MECKLENBURG COUNTY
Park and Recreation Department

MEMORANDUM

DATE: July 25, 2023

RE: Rezoning Petition #2023-039
PID# 18736112

RZ1-00

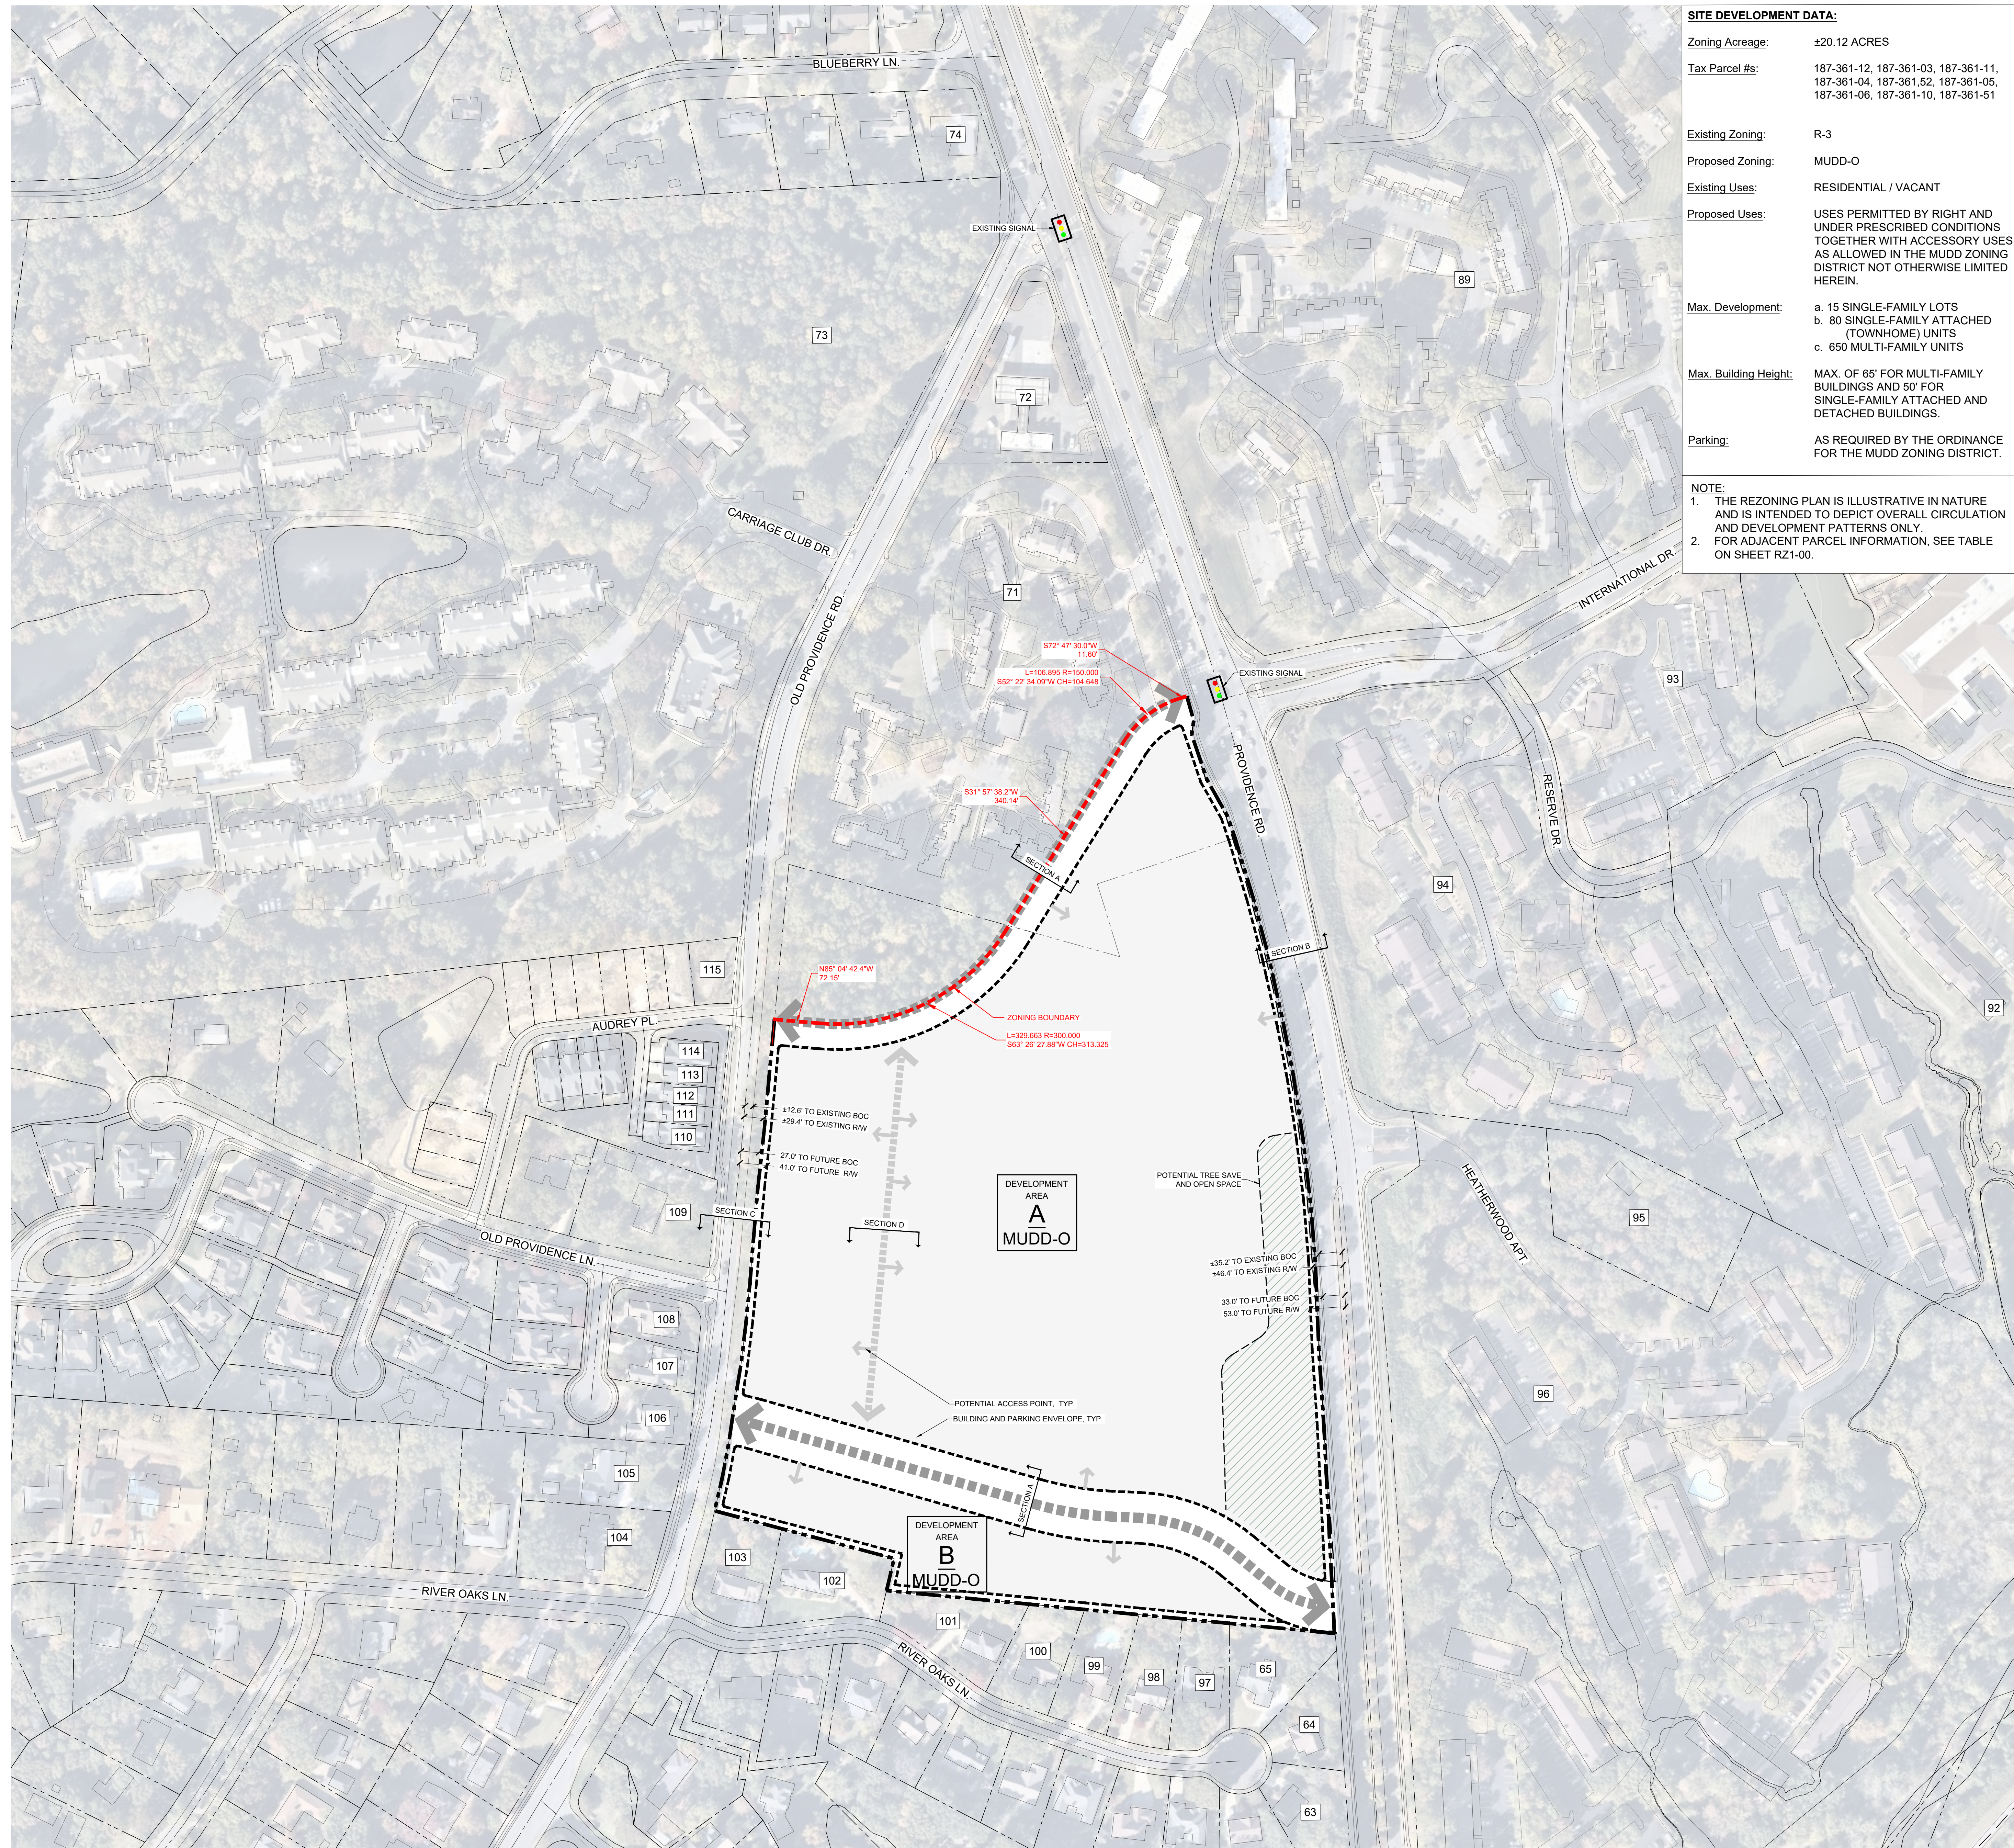
MCPR requests a minimum of **1.0** acres to be dedicated and conveyed to Mecklenburg County for a future local park. This requested park land shall be adjacent to a public right-of-way for access and is conducive for the development of the typical amenities found in a local park and cannot include tree save parcels or stormwater BMP's. Parkland dedication shall be conveyed by the first CO.

Additionally, MCPR requests a bike/pedestrian connection to the existing McAlpine Creek Greenway trail.
